Gatwick Airport Northern Runway Project

The Applicant's Written Summary of Oral Submissions
ISH 8: Good Design

Application Document Ref: 10.49.3

PINS Reference Number: TR020005

Title
Surface Access Highways Plans
Engineering Section Drawings
APFP Regulations 6(2)
Sheet 5 - North Terminal Sections

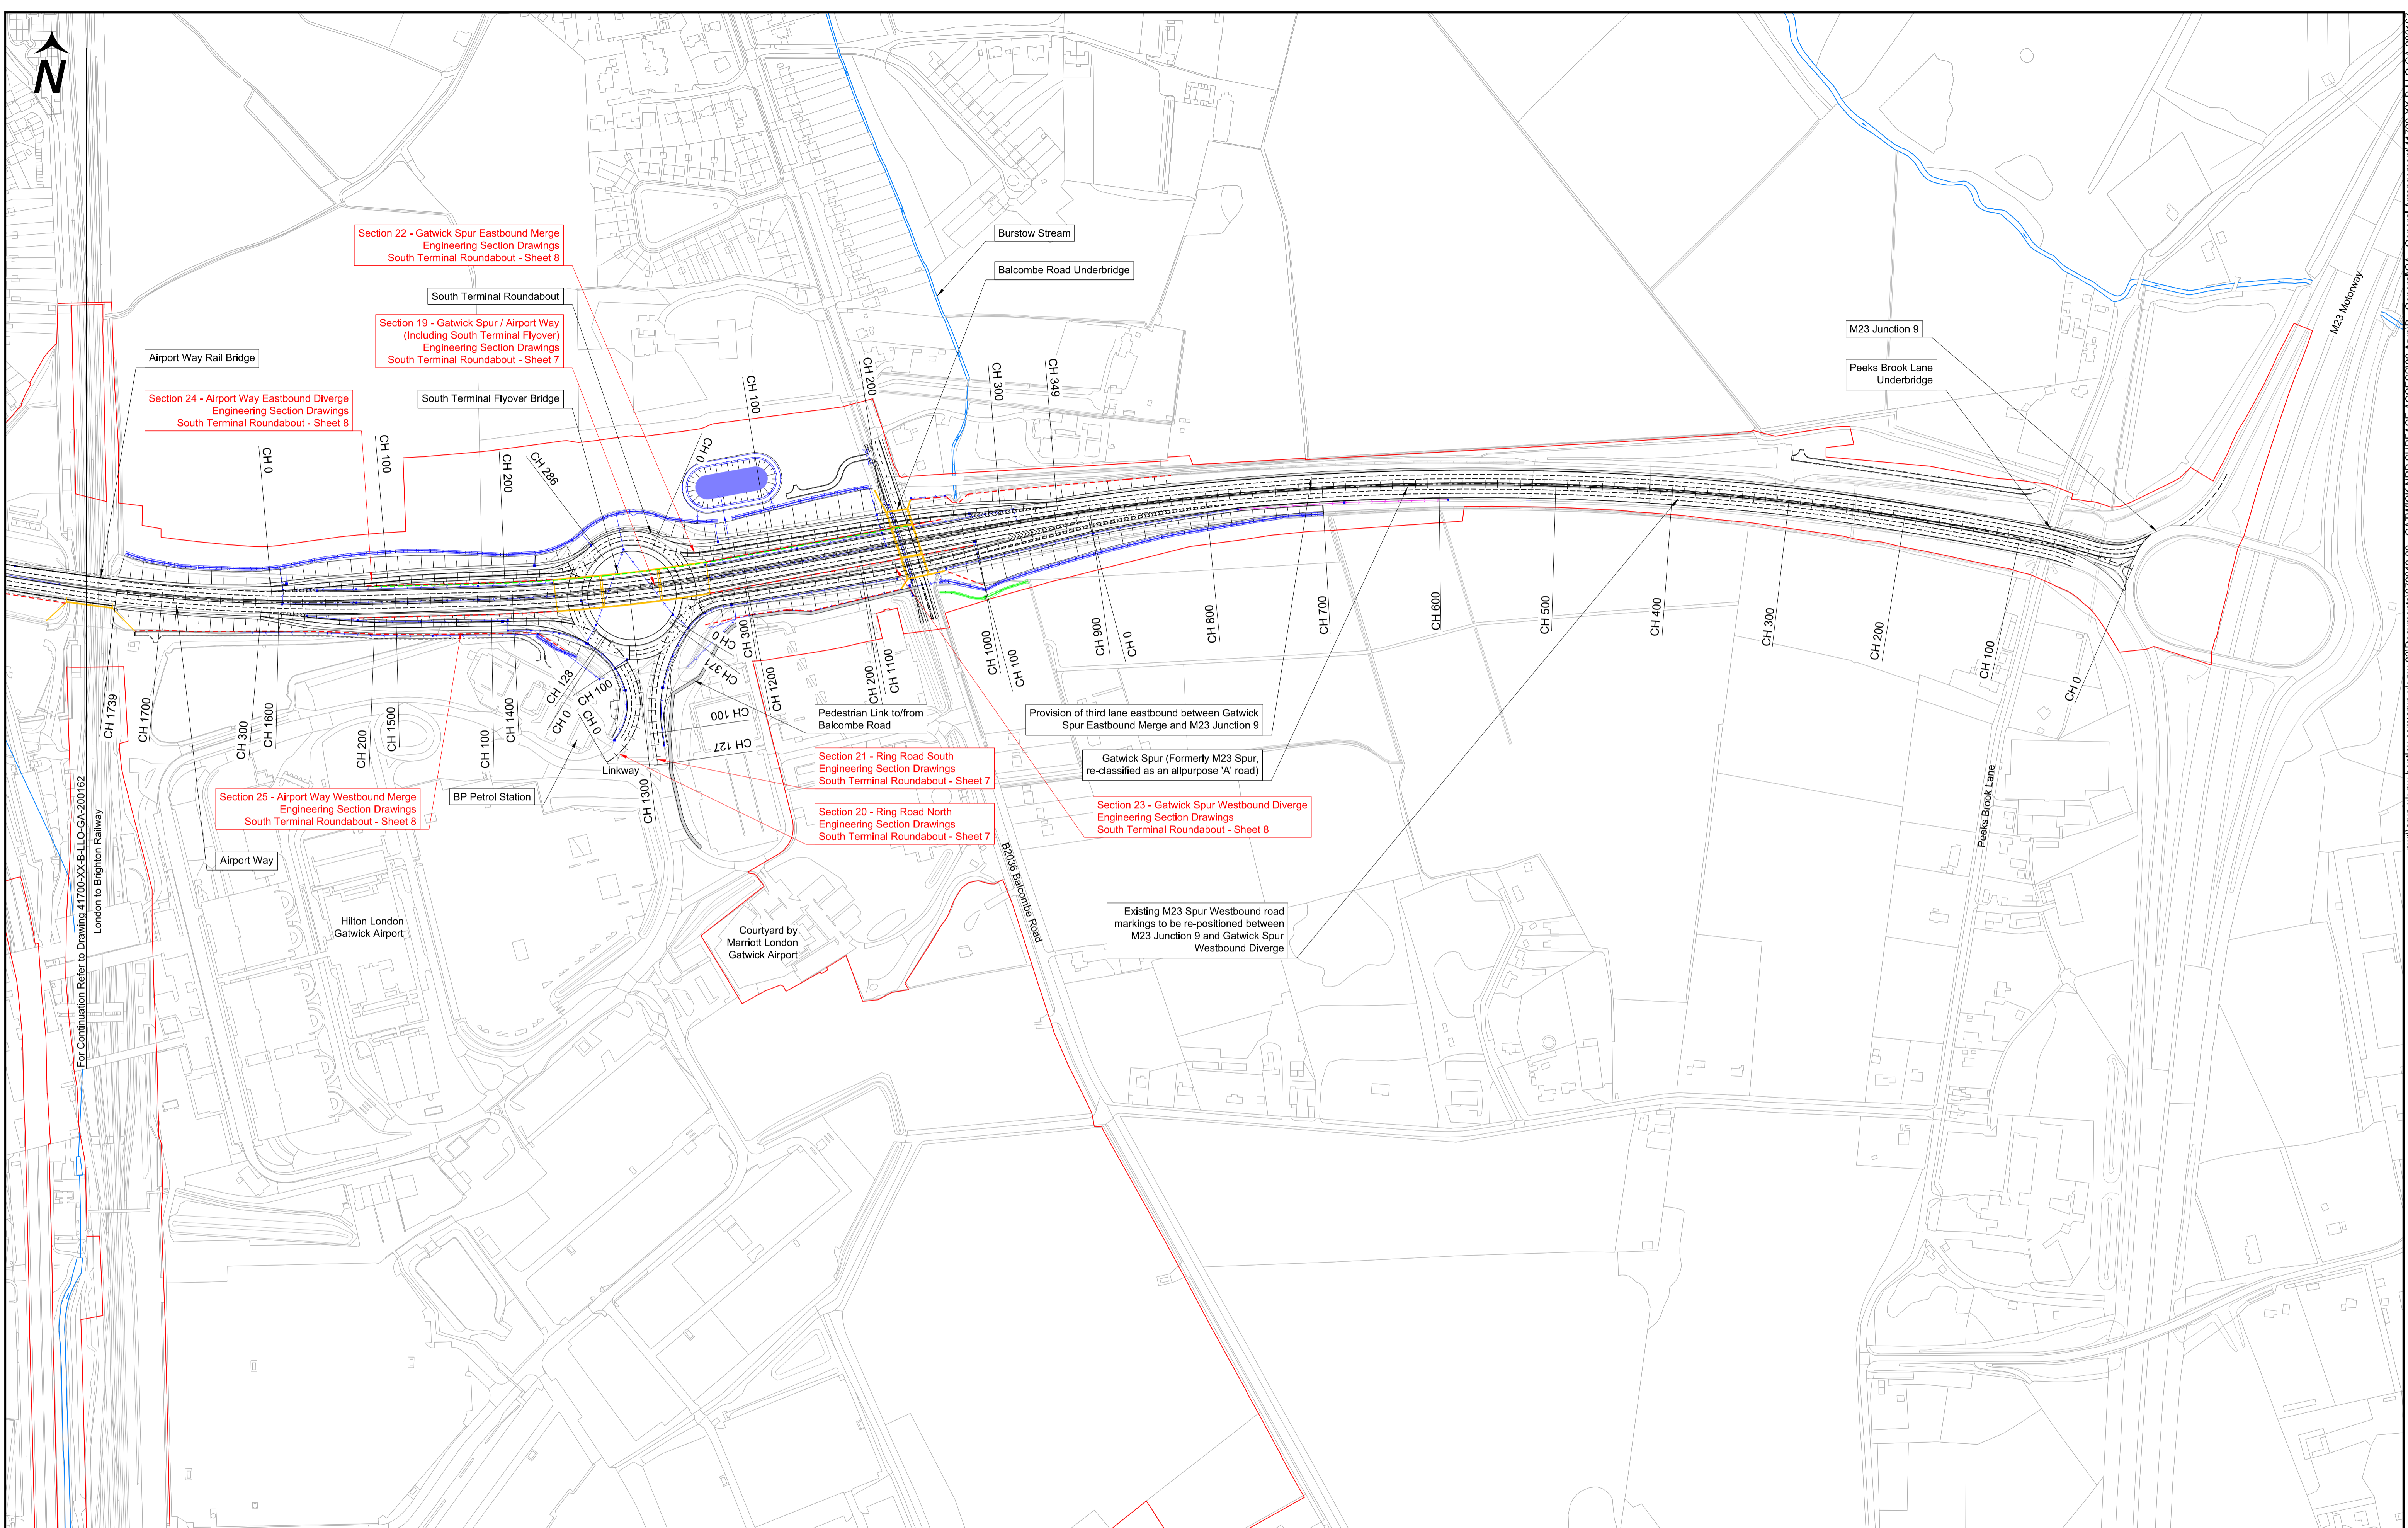
- 2.1.20 The ExA noted the proposals for the new grade separated flyovers at both the north and south terminals and asked whether there were any indicative elevations available and whether they should be added to the DAS.

- 2.1.21 The Applicant explained that indicative elevations for those structures are shown in the **Surface Access Highways Plans – Structure Section Drawings** [REP3-014] and the **Surface Access Highways Plans – Engineering Section Drawings** [REP5-019].

- 2.1.23 **[Post-Hearing Note:** the Applicant has responded to this query separately in the **Applicant's Response to Actions ISH8: Good Design** (Doc Ref. 10.50.3), in response to Action Point 5: "Incorporate relevant elevations of North and South Terminal road works from [\[REP3-014\]](#) and [\[REP5-019\]](#) into the DAS [\[REP2-032\]](#) to [\[REP2-036\]](#)".]
